**Planning Application Reference No.:** 3/2024/0817

**Address of Development:** Hawthorne Farm Persimmon Site

**From:** [REDACTED] >  
**Sent:** 11 November 2024 15:36  
**To:** Planning  
**Cc:** Nicola Hopkins  
**Subject:** Planning application 3/2024/0817...Approval of details reserved by conditions18 (landscape phasing scheme) and 19 (landscape management plan) of planning permission 3/2019/1104.  
**Attachments:** 20240702\_105850.jpg; 20240702\_110405.jpg; 20240702\_105556.jpg

CLIENT: Persimmon Homes
 PROJECT: Land off Hawthorne Place, Clitheroe
 DRAWING TITLE: Planting Plan (Sheet 1 of 2)
 SCALE: 1:200 @ A0
 DRAWING NO: REV: M
 DRAWN BY: CO AM
 CHD BY: AM
 DATE: 23/06/2020
 P: 1239.19.03

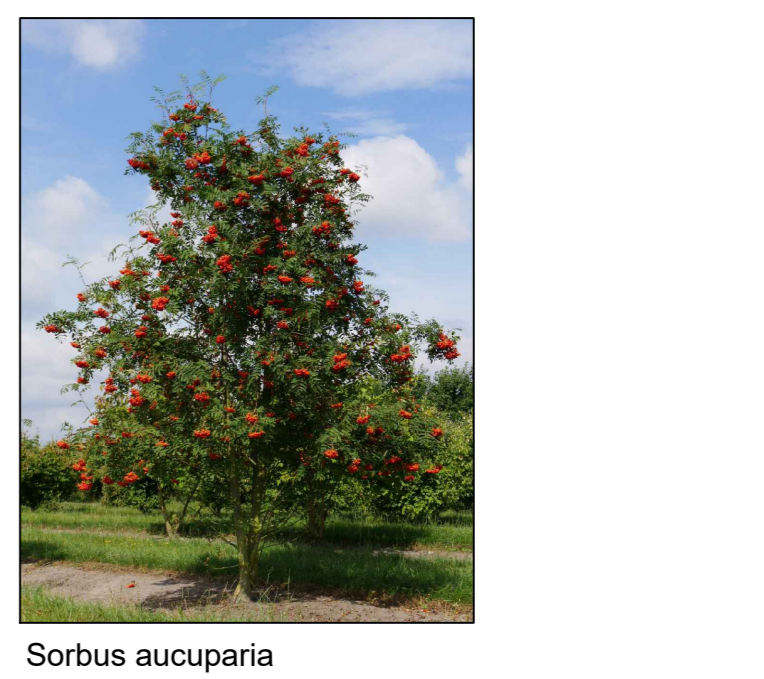
Whilst the application is difficult to understand as the written explanation of the landscaping and planting planned seems to differ from that on the drawings it would seem that Persimmon would like to plant a hedge that would be 8M tall on top of the now ridiculously built up field [REDACTED]

██████████. This would mean a roughly 10 m high barrier to light that would – if maintained in the same way as existing boundary strips be allowed to become unkempt and loom ██████████. The distance between ██████████ 2.5 – 3M and the developers are suggesting fitting a pathway and fence in adjacent to the house leaving only 1.5-2M for the grassed slope, drainage, culvert and an 8M hedge. This is clearly and plainly ridiculous and should not be allowed. It will cut out all sunlight ██████████. They even describe the provision of this hedge ██████████ be an unusable dead patch of mud.

Then there is the matter of light, legislation is in place to protect people from situations such as this. How can a permission be granted where there exists a right to light? We cannot see how an 8 foot fence will not affect light levels when placed so close and high upon the boundary, never mind an 8 metre thick Laurel hedge. Can it be shown with light testing that the existing properties will not be affected?

DRAWING TITLE:
Section A-A1 / Construction Detail

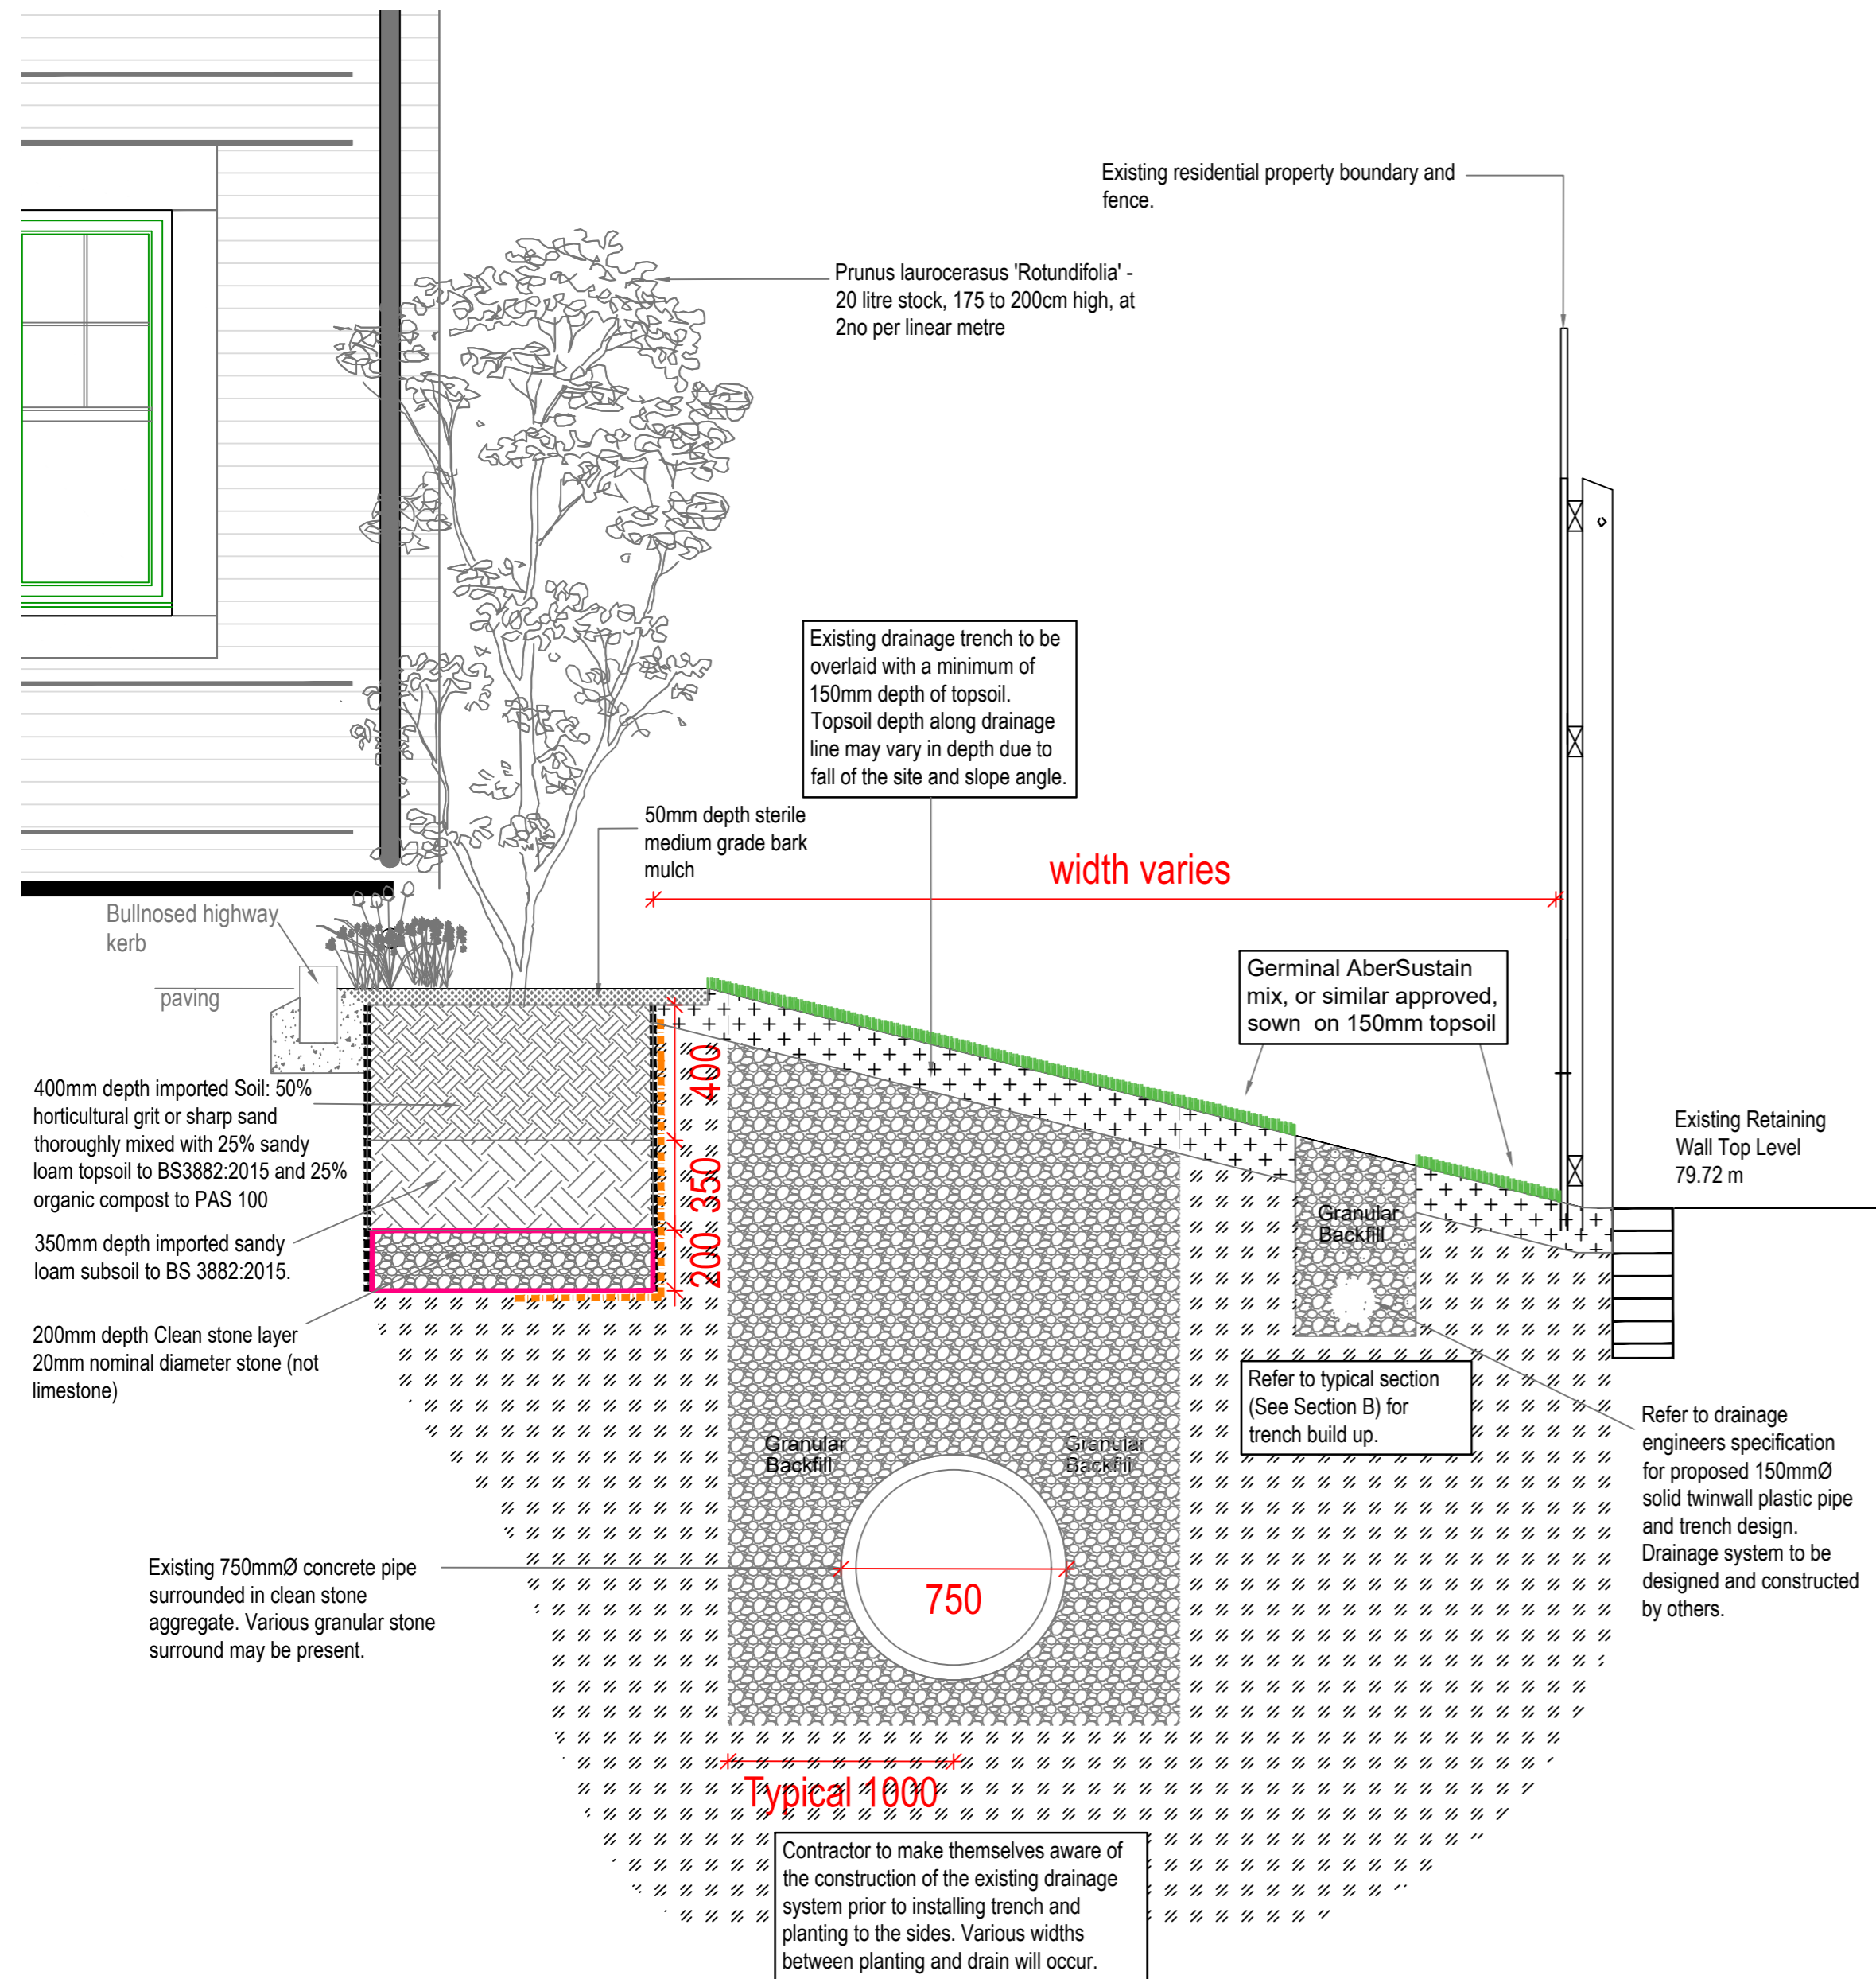
In this application they have provided cross sections of the land carefully avoiding the narrow section between [REDACTED] of their site. This section does not have room for the proposed 3 in 1 slope and will be much steeper than this risking land slip and meaning their proposed solution to water run off is unlikely to work. The field as previously explained was significantly lower than [REDACTED] which prevented [REDACTED] from flooding. Persimmons proposal is for a steep slope running onto our lawn that would rely on water soaking into a 15cm pipe to avoid it flooding [REDACTED]
